ENG-SF20015-R2-CD-redlines.pdf Markup Summary

SF-20-015

STRM_19 PROFILE STA 0+00.00 TO 13+29.82 PRIVATE (SRMD)

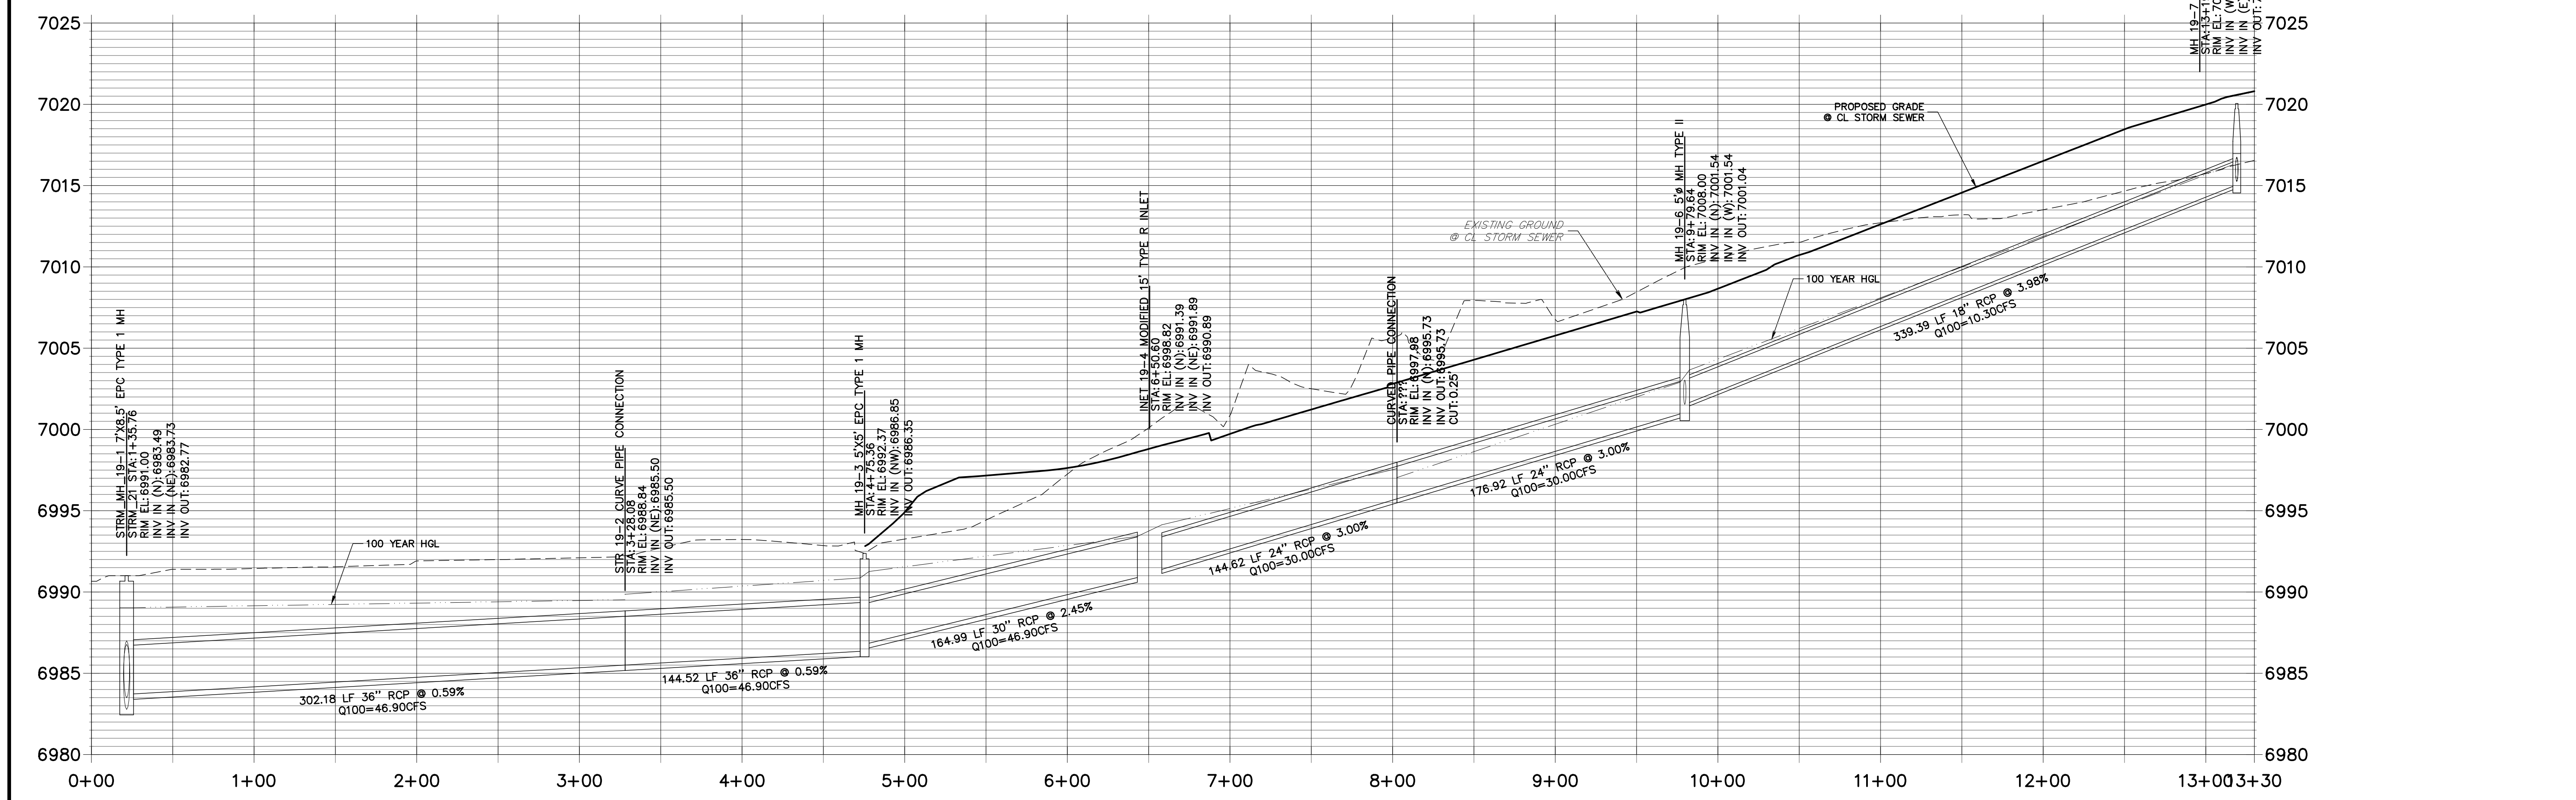
STRM_19 PROFILE
STA 0+00.00 TO 13+29.82
PRIVATE (SRMD)

**TEMPORARY DITCH PROFILE
STA 0+00.00 TO 12+00.00**

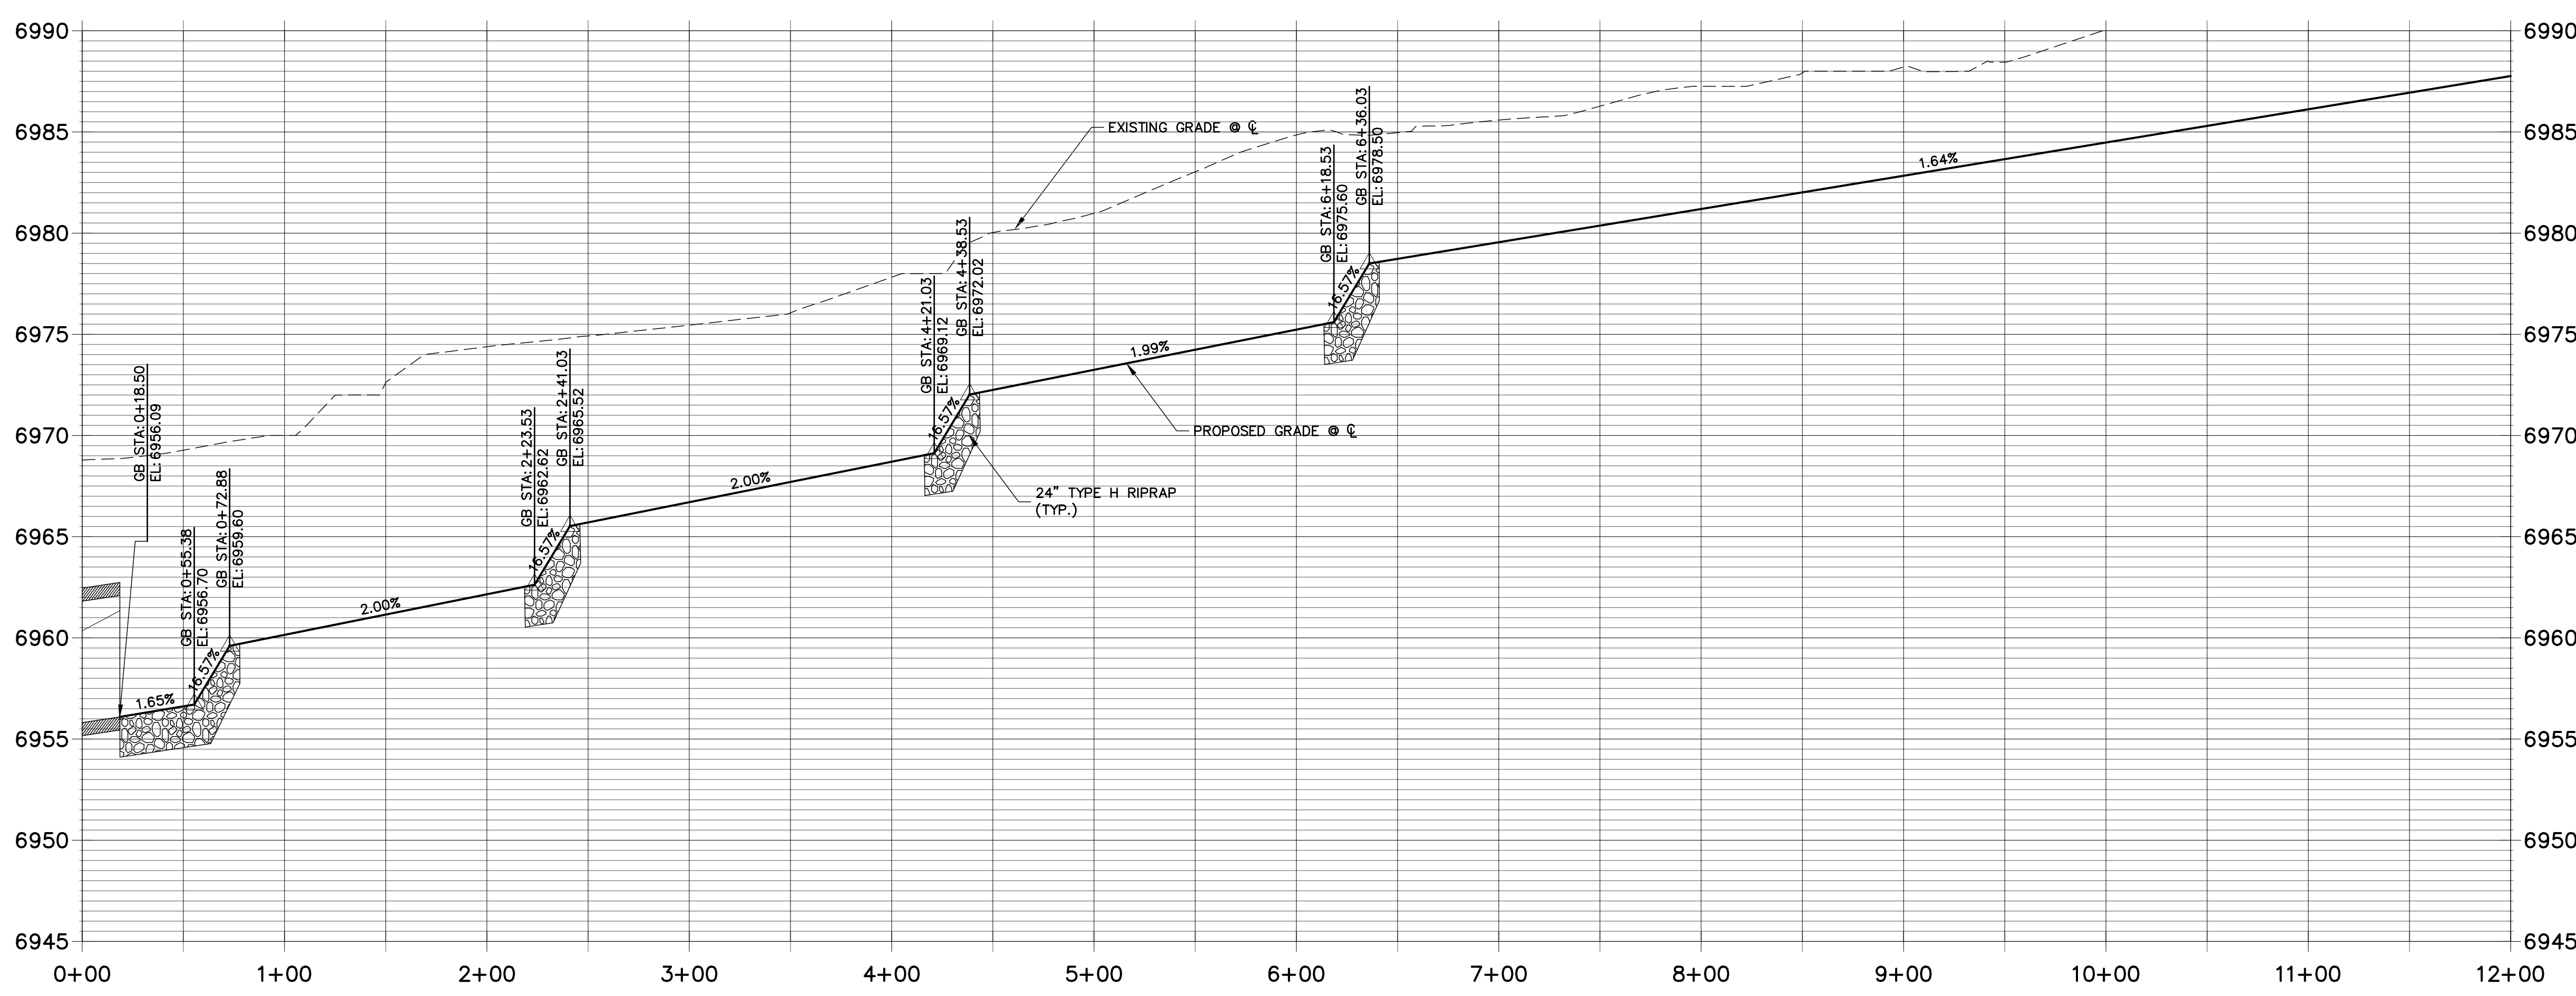
Label ditch lining (what are velocities / shear stresses?)

Label ditch lining (what are velocities / shear stresses?)

UTILITY SERVICE LOCATIONS

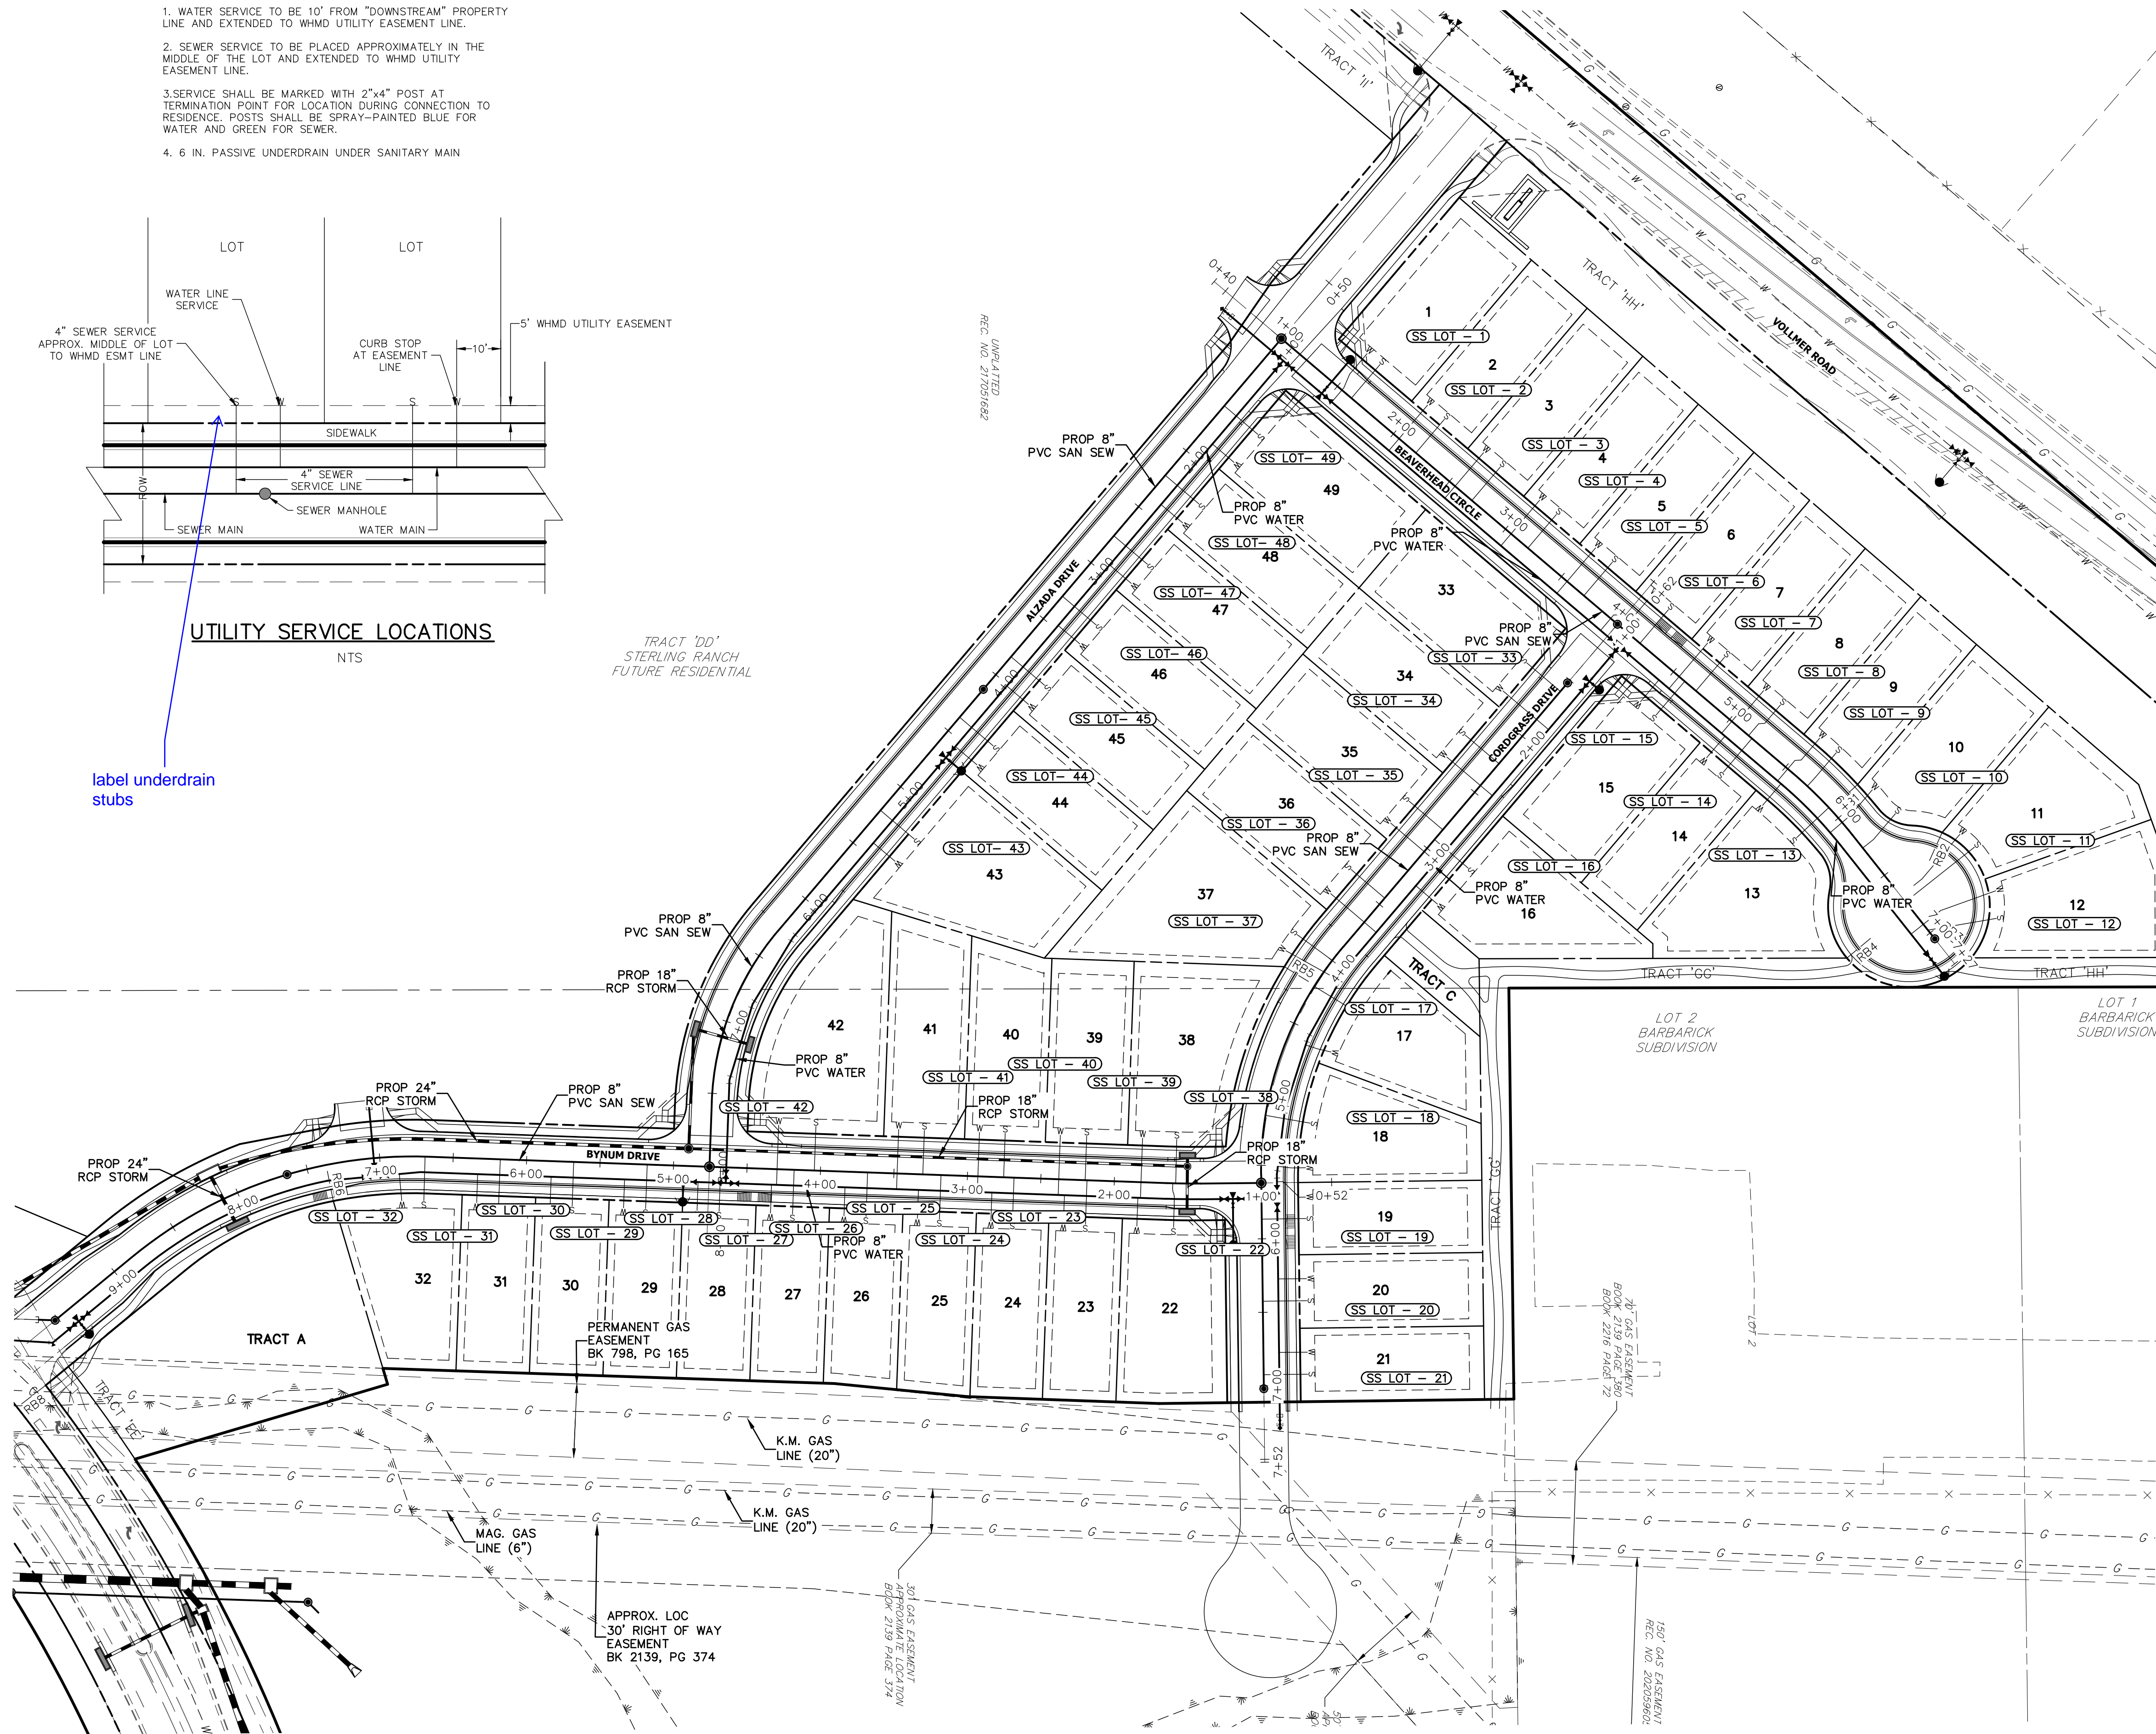
label underdrain stubs
